Proposed redevelopment of land to provide 13 no. new dwellings to include 4 no. 2 bed houses, 6 no. 3 bed houses, 1 no. 4 bed house & 2 no. 5 bed houses. Together with associated access, car parking, landscaping & retention of existing property
Greenoaks Barnham Road Barnham

Thank you for your internet representation made on 20th July 2011 which has been recorded as **an objection** with the comments as follows:

RBA 895 - 50 P8

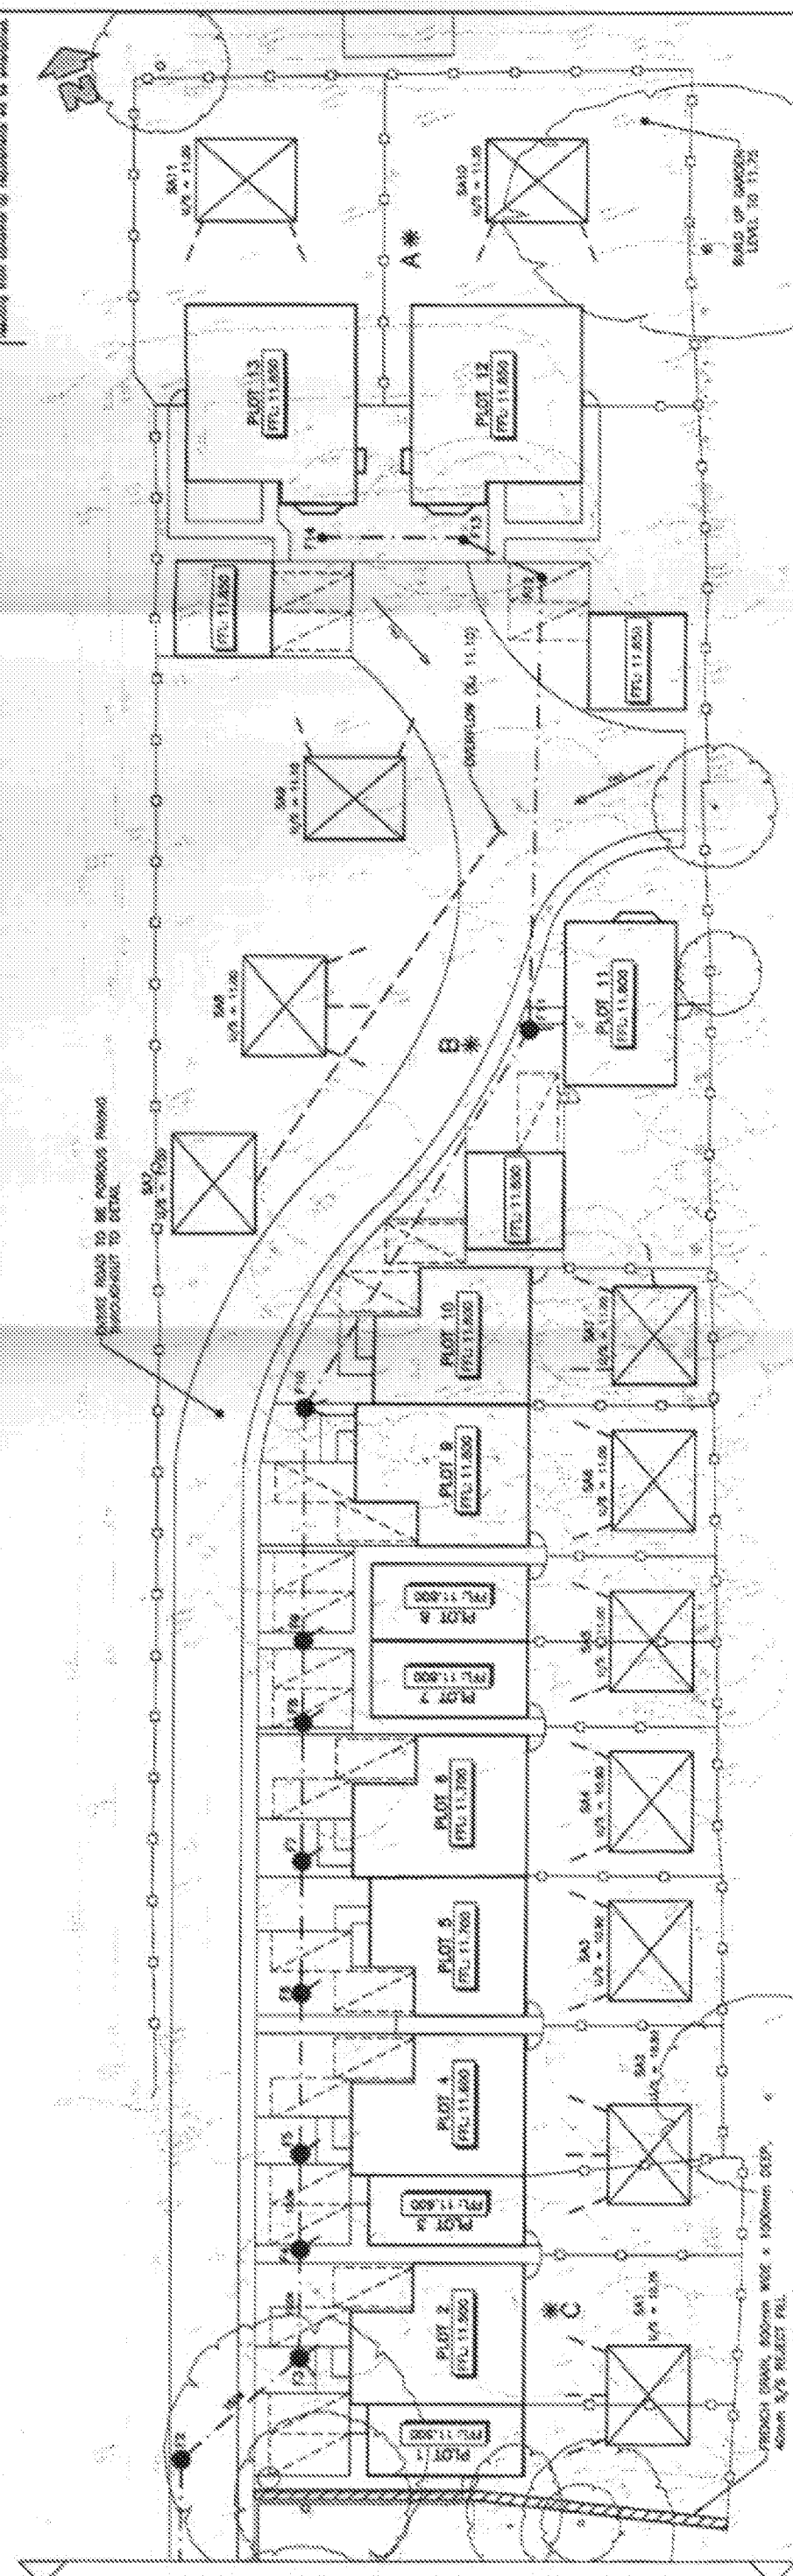
All the soakaways shown on drawing RBA895/50 are less than 5 meters from the houses. It also shows 10 soakaways and a French drain are less than 2 metres from the proposed tree, hedge and shrub planting. Expert advice identifies that tree root invasion will seriously reduce the effectiveness of the soak away. □

STREETSCENE LOOKING EAST

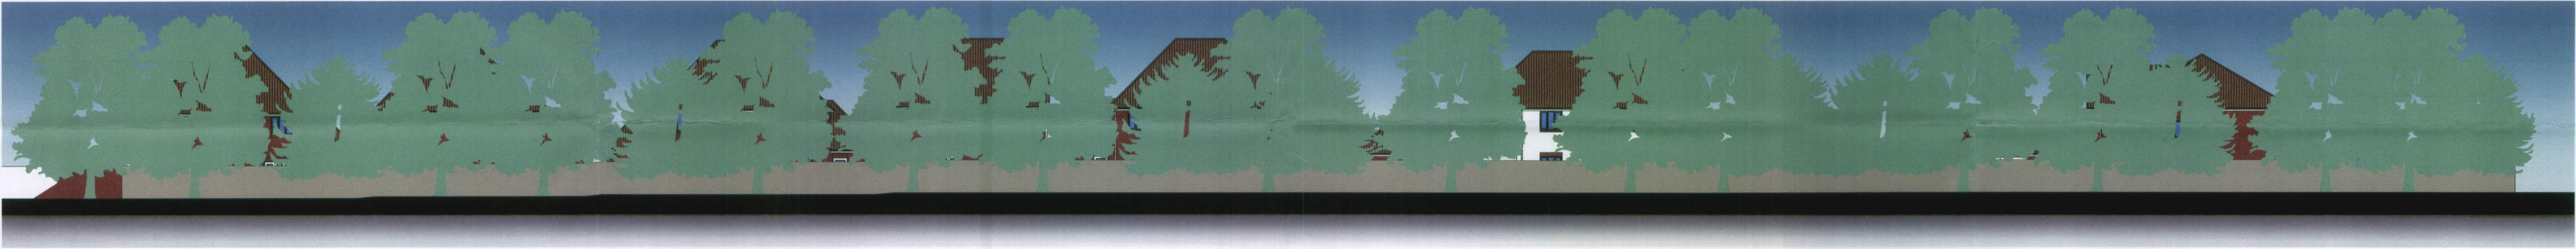
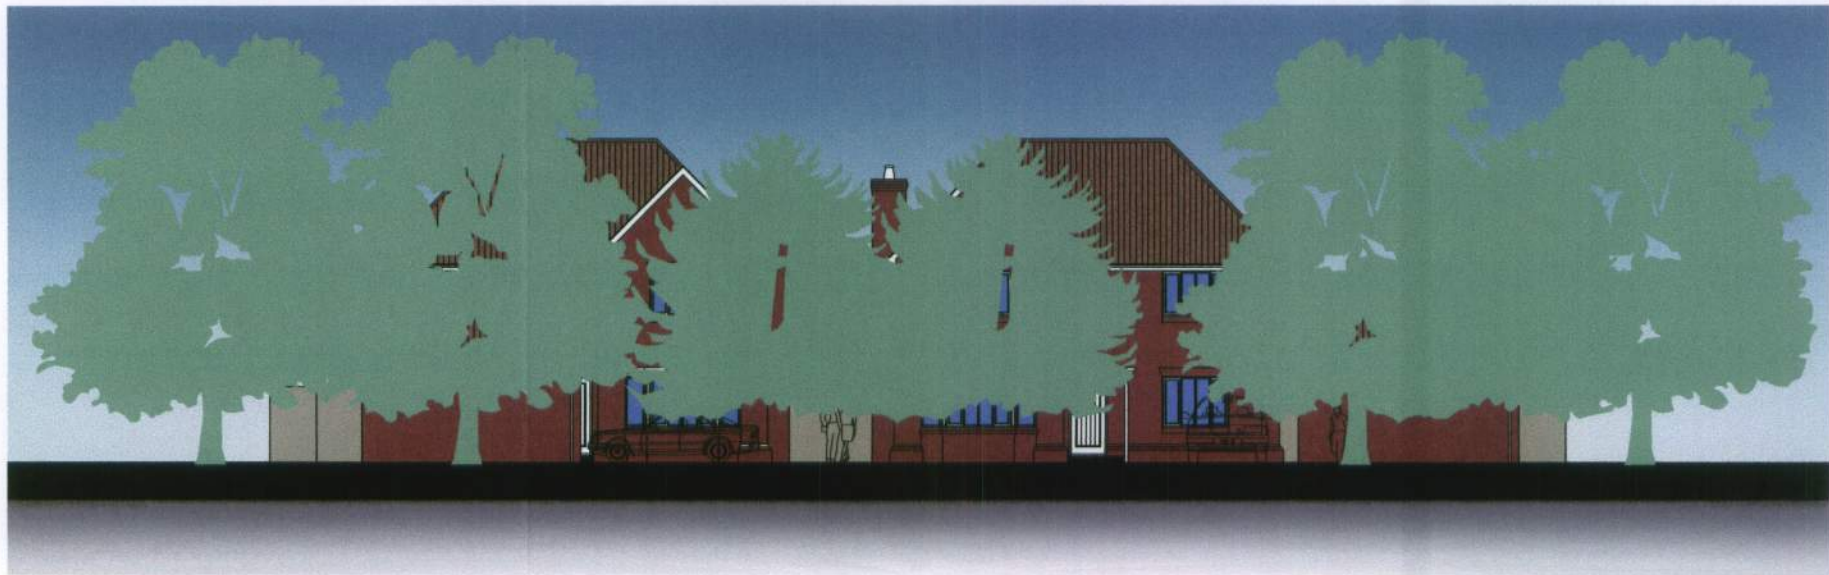
Also, this proposed development would be fully visible from the Strategic Gap, and therefore totally unacceptable to the character of housing in the area. The Hornbeam hedging beside the access road would not ever screen the houses from the Barnham Road and the Strategic Gap, therefore the Vivid Design Studio street scenes are purely conjectural. This has been a sticking point on all the multitude of applications that have been through the process already. Apart from the aesthetics, the drainage issue greatly concerns us as this proposal would significantly add to the problems already experienced with the local flooding issues. The surface water is already a real problem, especially during the winter months. □
